East Pye Solar – EN0110014

Written Representation Following Matters Raised at the Open Floor Hearing

East Pye Solar DCO – EN0110014

Residential Properties within 100m

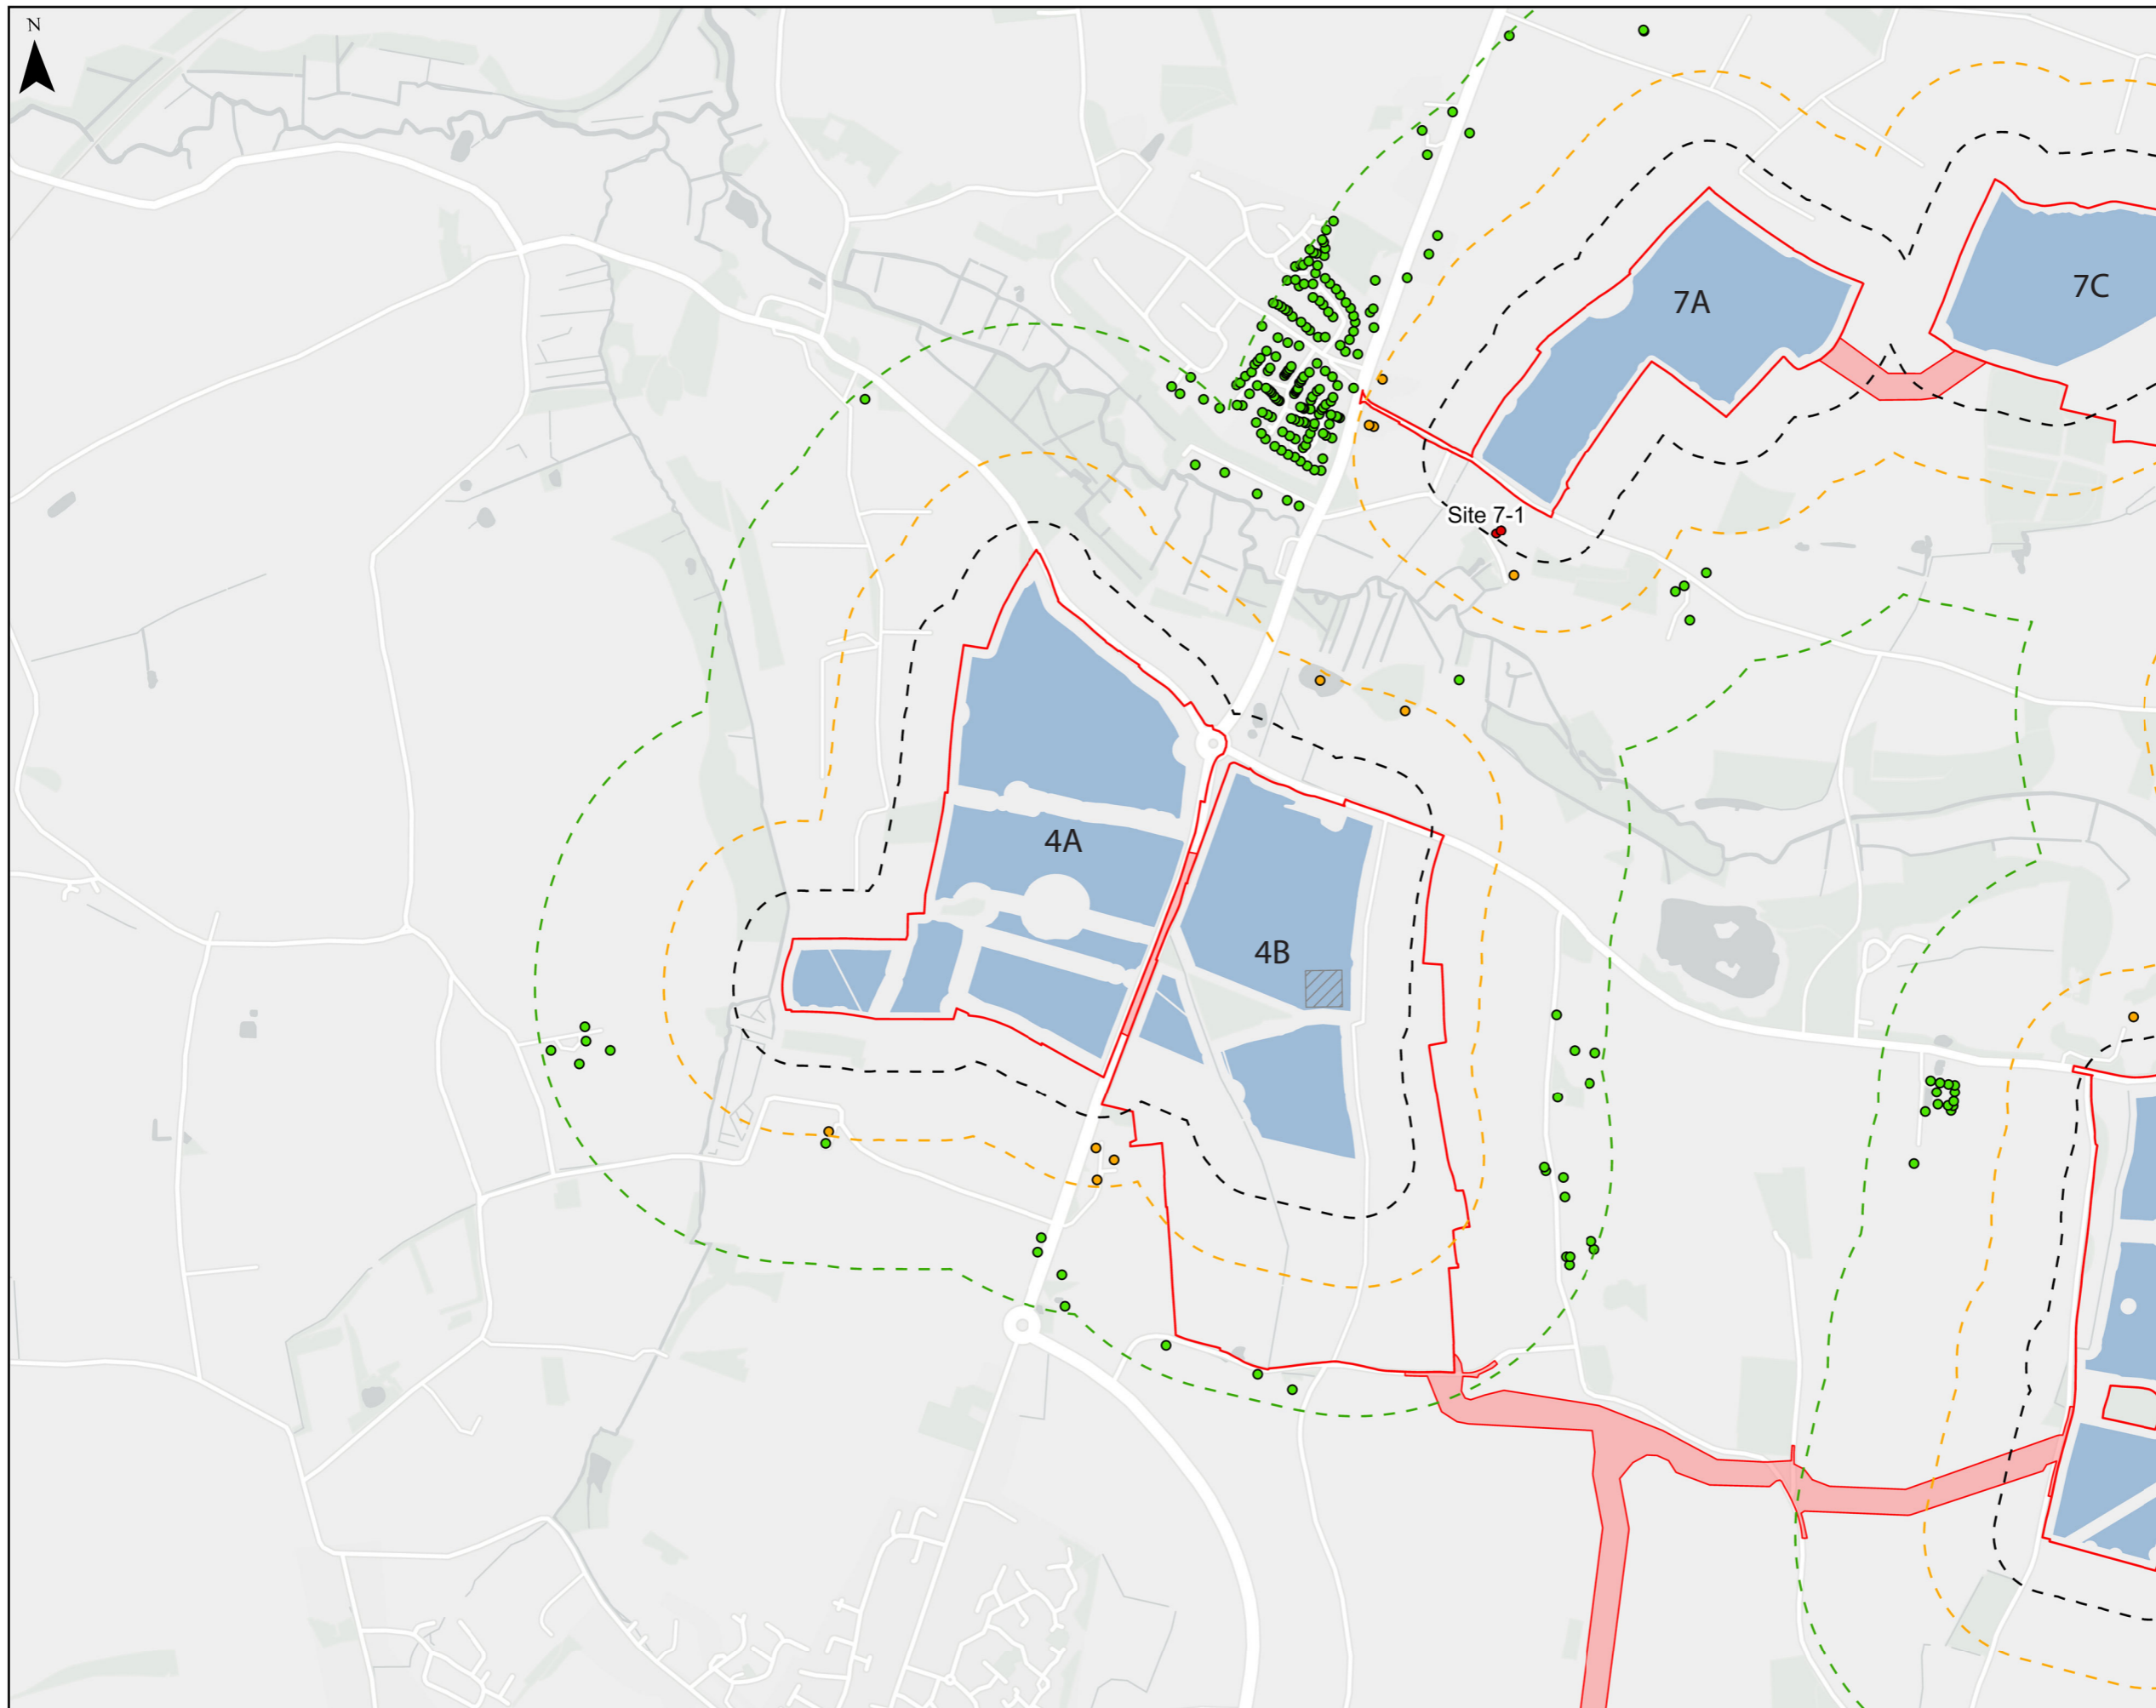
As I explained at the hearing, my home is immediately adjacent to Site 5a. My garden lies approximately **11 metres from the Order Limits**, and my driveway lies between proposed construction access points A23 and A24.

Despite the fact that my residential property and garden abut the proposed construction route for Site 5 and Sites 7A-E with my property entrance sitting between the proposed permanent access points A23 and A24 on this route, no recognition of this has been made by the Applicant.

I remain concerned that I as an owner and occupier of the property identified above, I have not been identified as a Category 3 interest despite the evidence shown above.

However, it does not explain **why my home specifically was excluded**.
